ASSESSMENT REPORT

Orange Waste Project - Site Layout Changes (MOD 1)

2 PROPOSED PART SITE PLAN

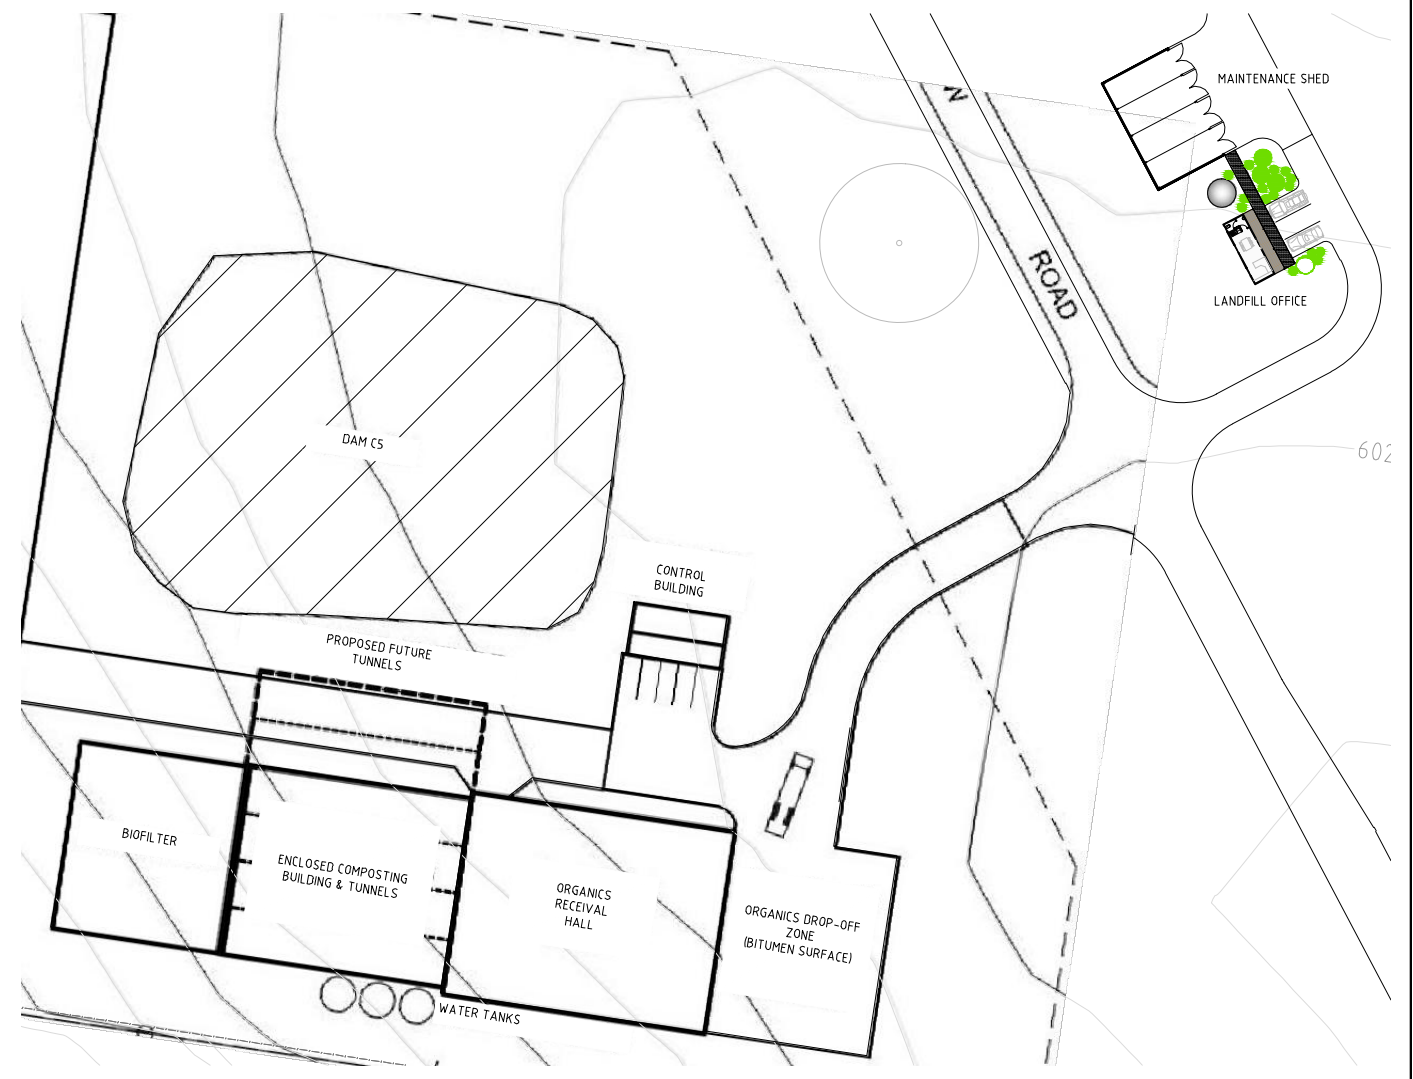
A number of submitters raised concerns about the plans in the original modification, which only illustrated the proposed reconfiguration of Dam C. Concerns were raised that since the plans did not show the other approved surface water dams (A and B) at the ERRRC site, that these dams could potentially have been removed from the site.

Cabonne Council and a number of public submitters (eg. the Hub Action Group) also raised concerns that the overall capacity of Dam C had increased from 0.5 to 10 mega litres (ML) which would exceed harvestable rights for the ERRRC site.

In its RTS report, OCC provided amended plans of the ERRRC site to show all current and proposed surface waters dams. OCC clarified that the proposed modification did not seek to change Dams A and B (located adjacent to the landfill area) which would remain in accordance with the current approval. The proposed modification would see Dam C, located in the vicinity of the composting facility at the ERRRC site, separated into five (5) separate dams (Dams C1–C5) (see Figures 4 - 5) with an increased water storage capacity.

OCC indicated that following the project's approval, detailed water balance analysis had been undertaken which concluded that the original water requirements for the ERRRC site had been under estimated (ie 0.5 ML) and that around 5 ML of water would be required for its operational activities.

Dams C1-C5 would now have a combined capacity of around 10 mega litres. OCC indicated the extra capacity in Dam C would enable the composting facility to store sufficient water for operational needs without any of the dams needing to be at 100% capacity (ie less than 10 ML). The increased capacity would also ensure that surface runoff during periods of high rainfall can be adequately accommodated, thereby preventing any uncontrolled release of liquid residue from the site into the local water environment.

Further, OCC advised that the function of Dams C1-C4 would remain unchanged for that which was approved and will serve to collect water (including stormwater) from the composting operation areas for re-use in the composting process. The function of Dams C1 and C2 would be for the capture and reuse of stormwater that has potentially been in contact with treated compost. Dam C3 would capture residual runoff from the composting process in addition to providing top up water for the compost process. Dam C4 would be kept less than 20% full and act as a back up for C3 in times of high rainfall. Dam C5 would be used as a fire fighting resource.

The dam design would remain consistent with the approval design incorporating a 900mm clay lined closed system where no discharge occurs. The compost maturation area would be bunded to prevent leachate run-off into surrounding soils.

Furthermore, the Department has also recommended additional conditions to ensure that the additional dams (C1-C5) are also constructed in a manner to include 900mm of clay lining material to manage any seepage issues.

2 PROPOSED SOUTHERN ELEVATION

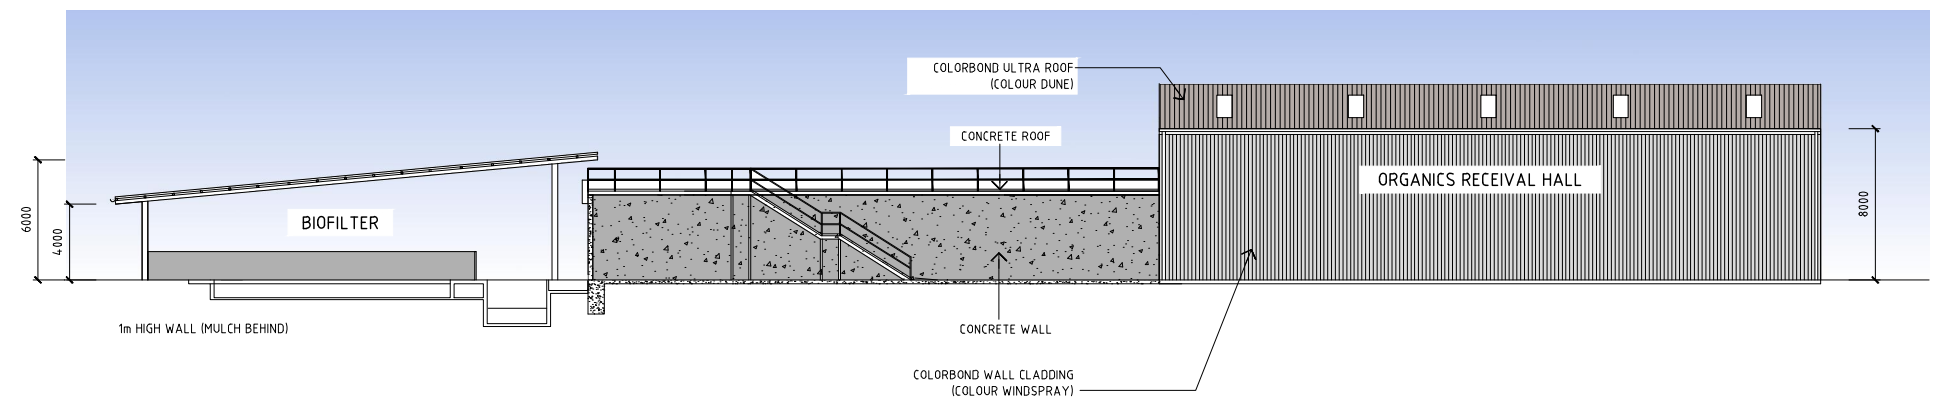
- the proposed additional water storage dams at the ERRRC site; and
- the design and alignment of the composting buildings at the ERRRC site and the potential resultant air, noise and visual impacts on nearby sensitive receivers.

- the presence of a shredder and the removal of screening/bunding at the ERRRC site;
- the design and alignment of the composting buildings at the ERRRC and the potential resultant odour and noise impacts;
- the removal of the Education Centre (and public scrutiny) from the ERRRC site;
- the additional water storage dams (C1 to C5) at the ERRRC site requesting clarification on dam capacity, lining, function, water source and harvestable rights;
- whether the proposed changes could be considered as a modification; and
- the potential for the modification to increase risk to the local apiculture industry.
